Consultation Response from KC, Highways Development Management
2022/92842 The Carlton Nursing Home, 25, Greenway, Milnsbridge, Huddersfield, HD3 4RZ
Change of use and internal alterations to former nursing home (C2) to form 12 apartments (C3)
Date Responded: 20-9-2022
Responding Officer: Mark Berry
Responding Ref: 2-11SE-5

Parking and Amenity Layout 1:100

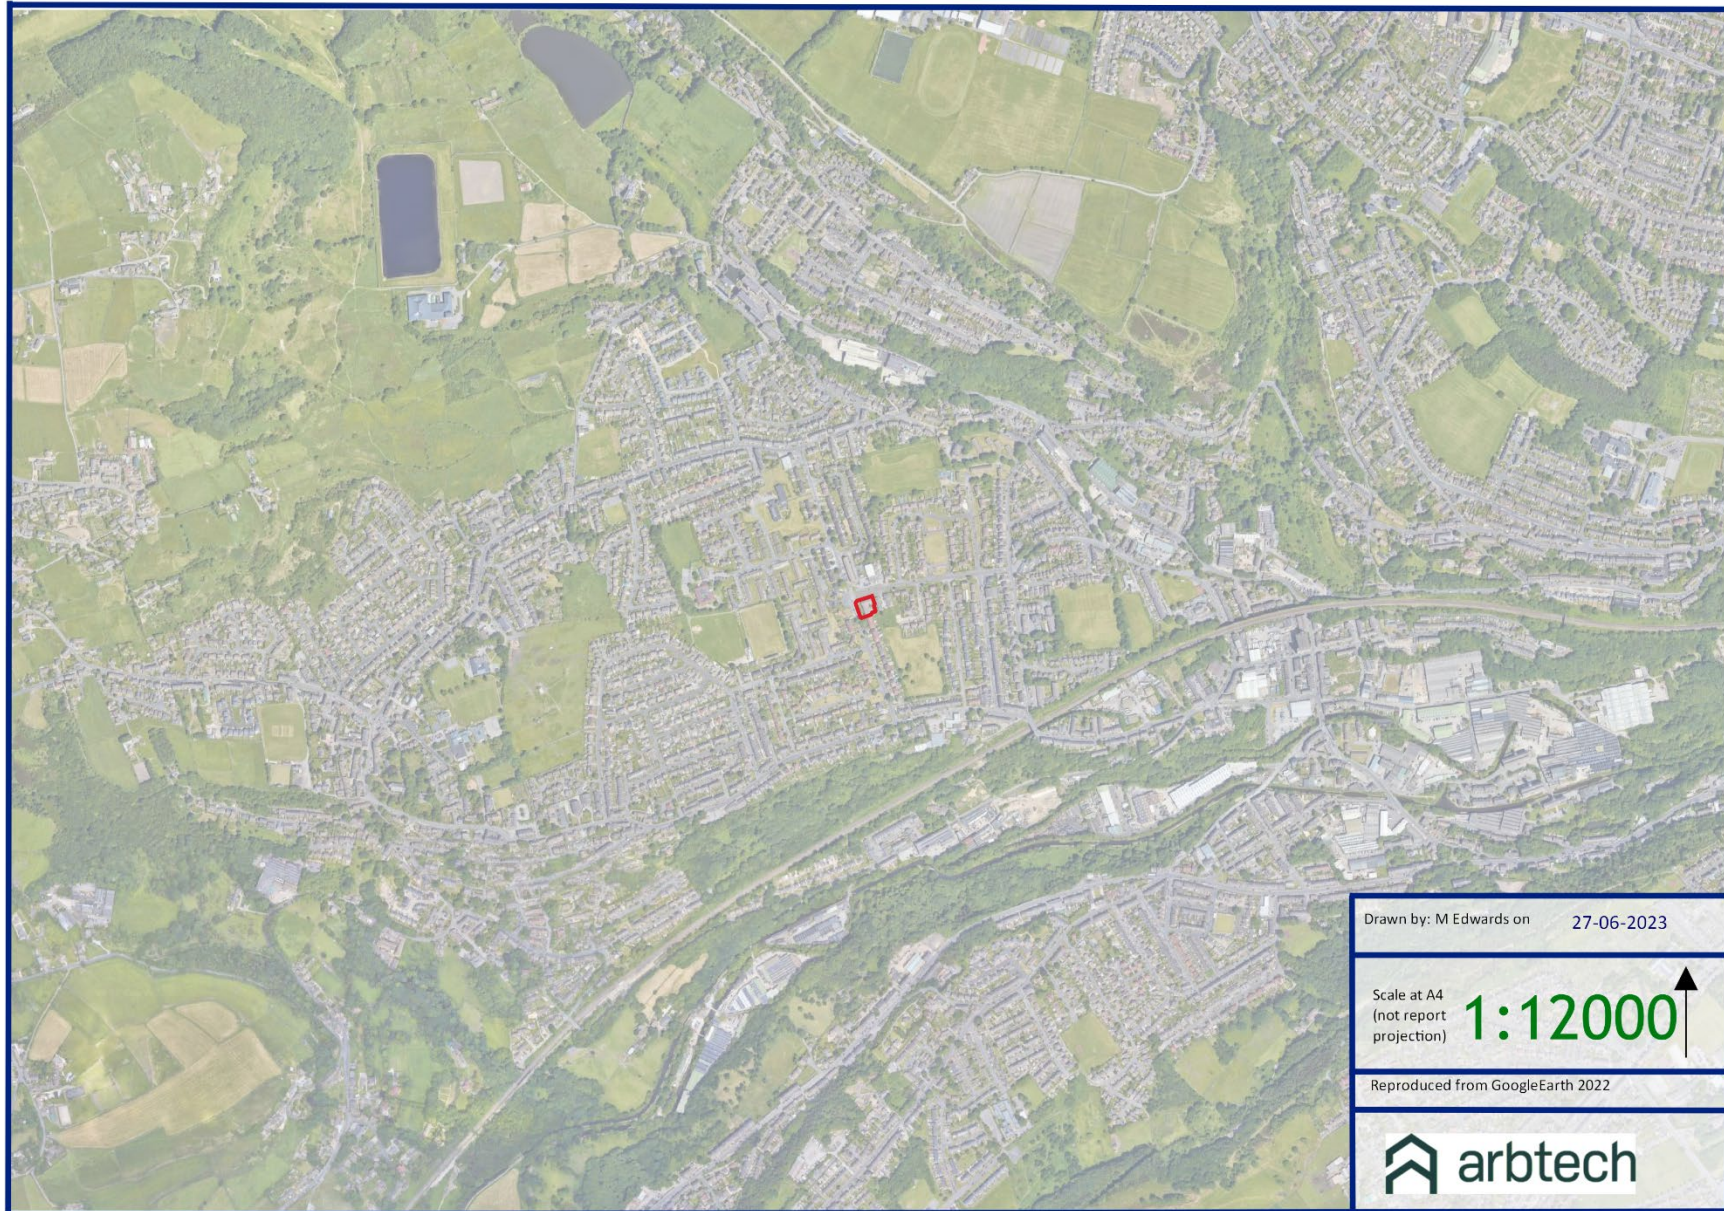
20 potential off-street parking spaces are shown on the Parking and Amenity plan number 2206/03.

1, The Parking and Amenity plan is vague and does not properly show footways or verges along Sycamore Avenue and Greenway.

2, The location of the proposed parking spaces takes no account of the existing traffic calming and pedestrian crossing point along Sycamore Avenue or the bus stop and bus stop markings along Greenway. All of which need to be shown to be retained or if practical (which is doubtful) re-sited.

3, Existing signs and street lighting columns are also not shown. Again, these need to be shown to be retained or if practical re-sited.

4, Parking spaces are also shown close to the Sycamore Avenue and Greenway junction which is not considered to be safe and is unacceptable.

Realistically HDM would consider that only possibly 6 off-street parking spaces can be provided at this site and not 20 as shown.

Based upon the above criteria 15 off-street parking spaces are required at this site which is unlikely to be possible.
